From: David Smith [REDACTED]
Sent: 06 October 2020 11:18
To: Planning <Planning@arun.gov.uk>; Planning.Responses <Planning.Responses@arun.gov.uk>
Subject: Objection to AL/67/20/HH

Westfield House,
Fontwell Avenue,
Eastergate.
PO203RU
06.10.20

We wish to object to Planning Permission AL/67/20/HH

SITE PLAN 1:500 @ A4

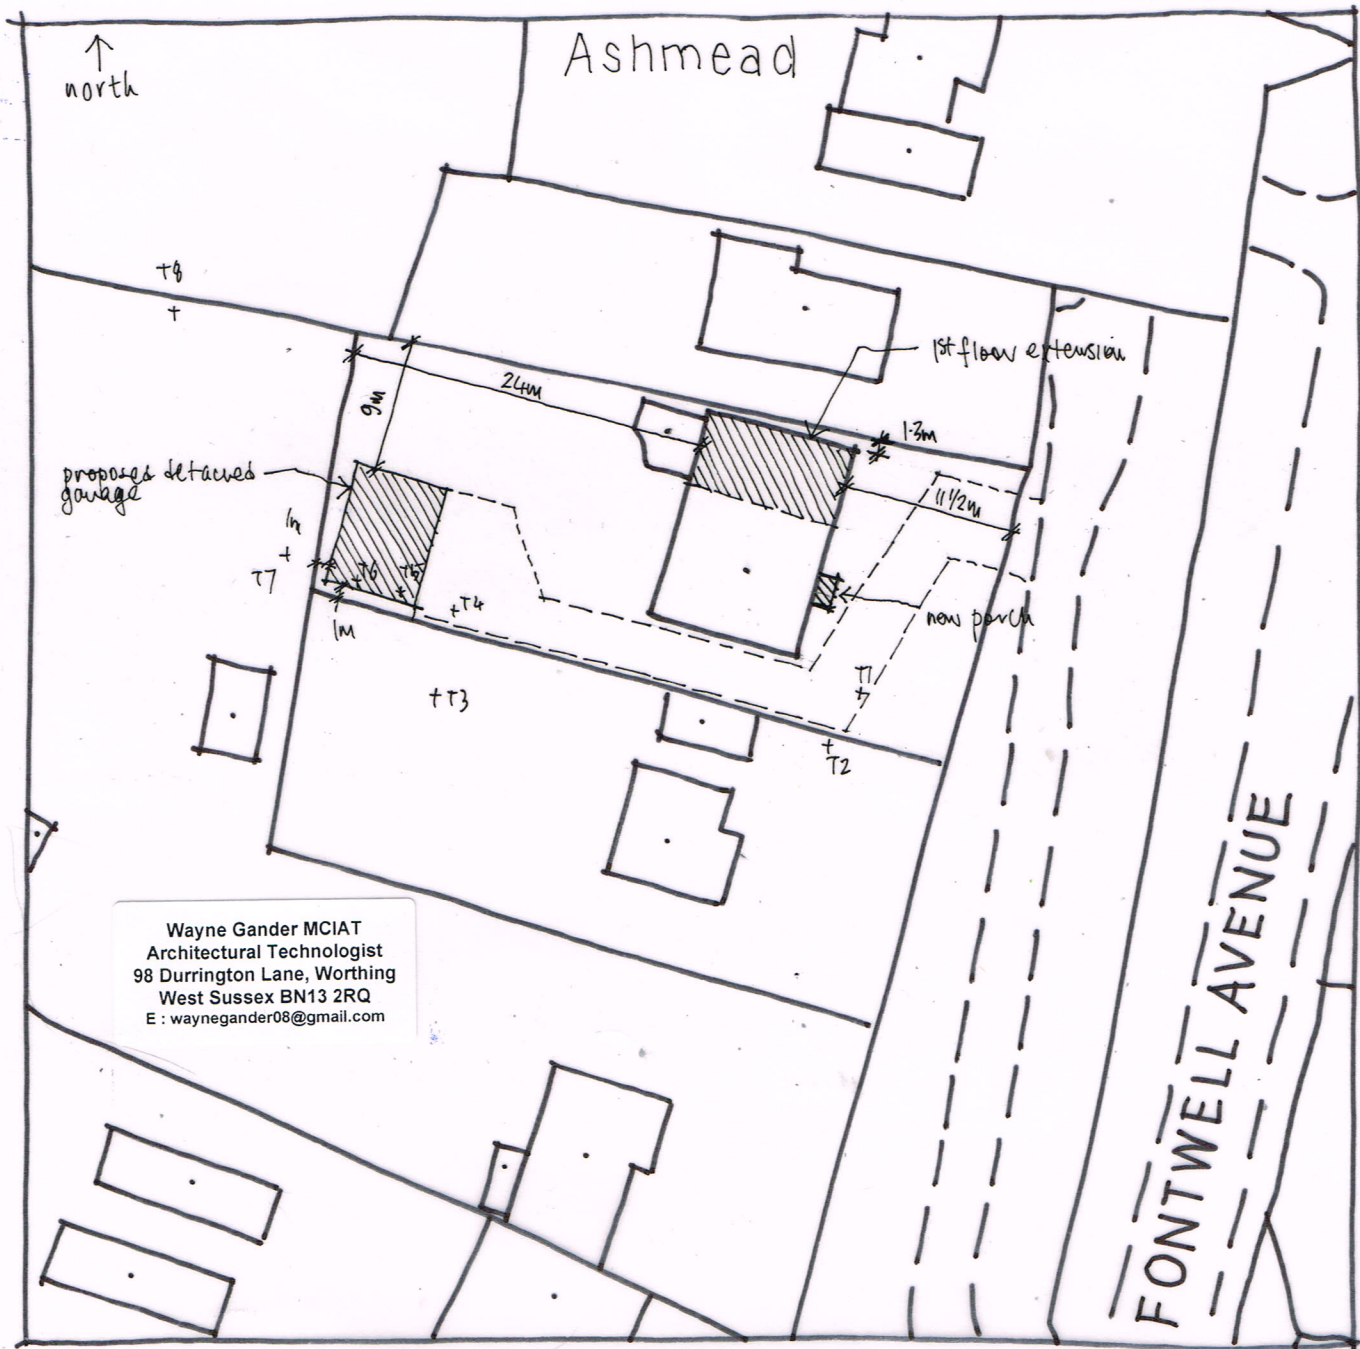
The positioning of three extra garages in particular, (detached from the main house) with living space above, at the very back of the site, would be completely out of character. They

would represent a separate dwelling, being surrounded by three other open back-gardens, to three adjacent houses, and be a very visible intrusion, especially as the land in this position, is much higher than the land on which the main house already stands.

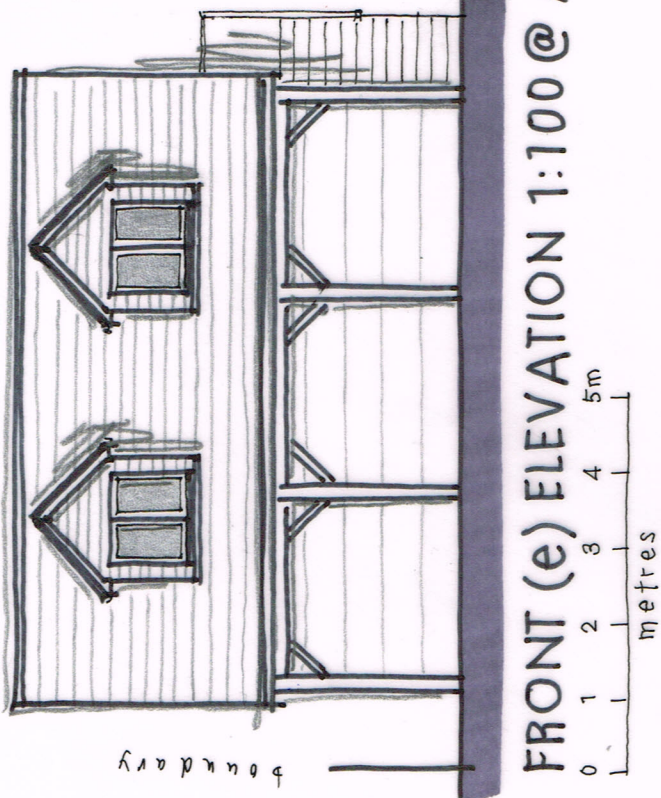
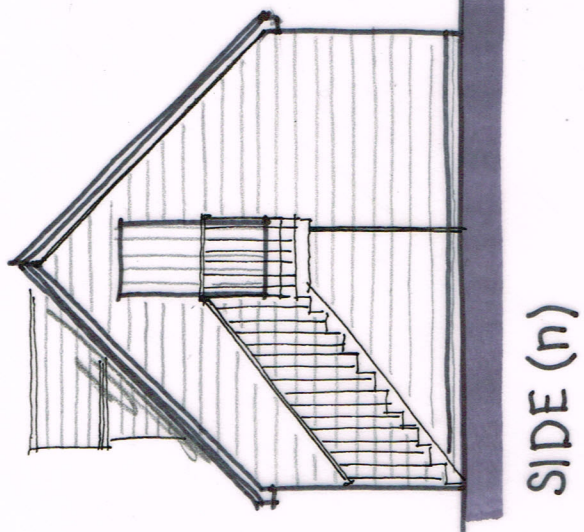
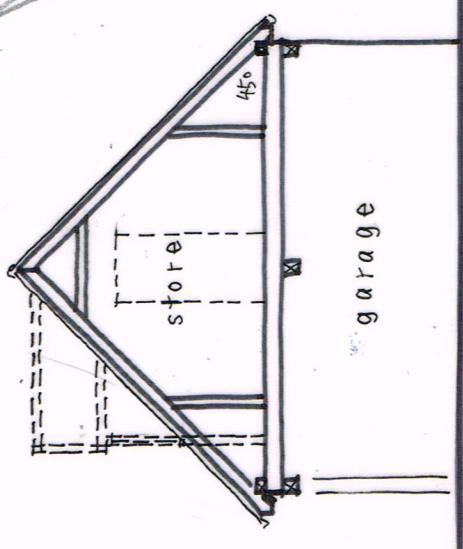
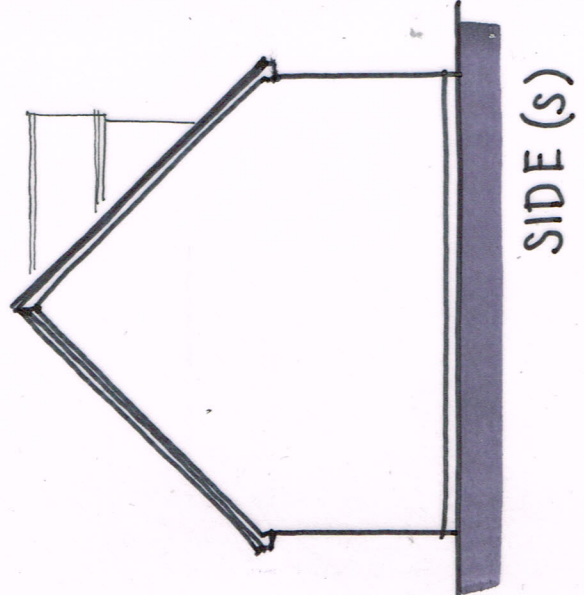
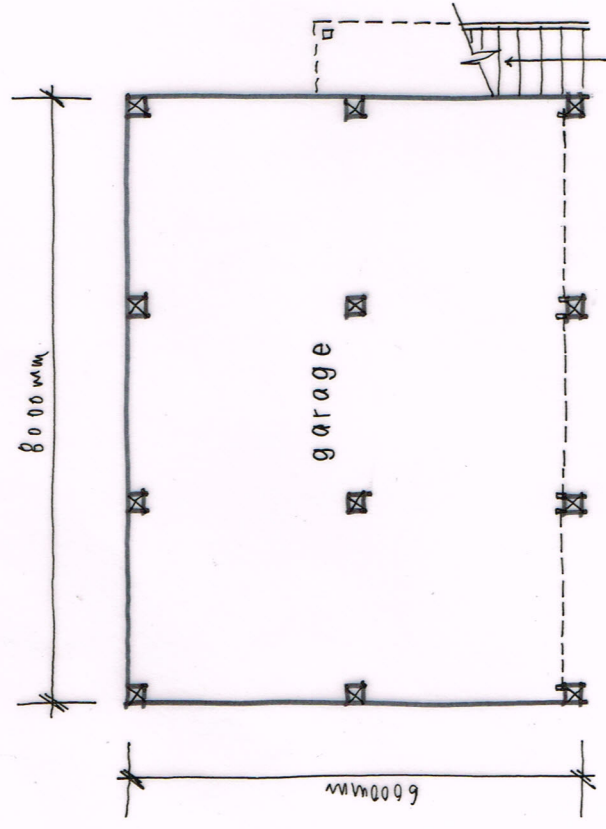
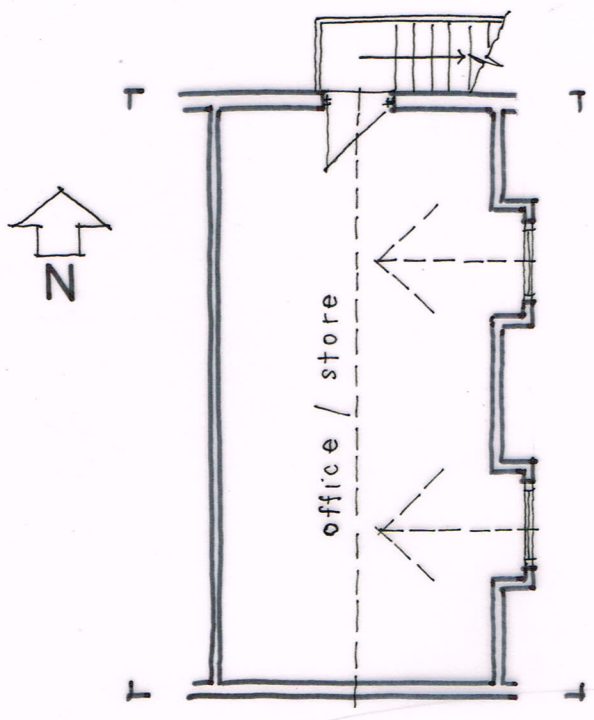
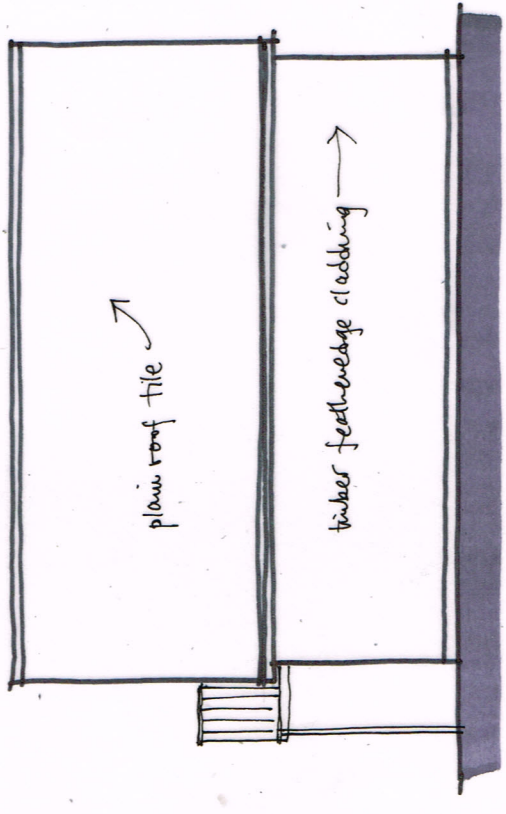
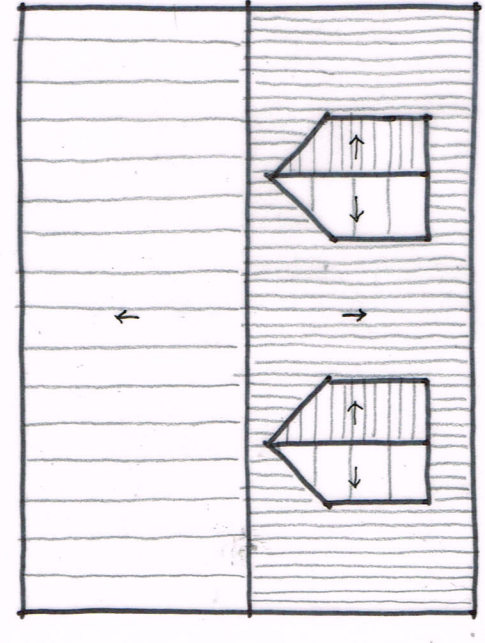
On the proposed plans for the detached garages, the rooms above are shown as an 'office and store.' Office and store, or 'extra living space', (as described on the planning application) would both conflict with the conditions already imposed on the house, by the covenant which exists on all three properties contained within this parcel of land. (Lulworth, Fairways and Westfield House.)

1. Only one private dwelling shall be erected on each of the plots. (The construction of separate living space above the garages would therefore be prohibited.)
2. No trade or manufacture or business other than market gardening may be carried out on any of the plots. (The construction of an office and store would suggest commercial activity.)
3. One private garage may be erected for each house.
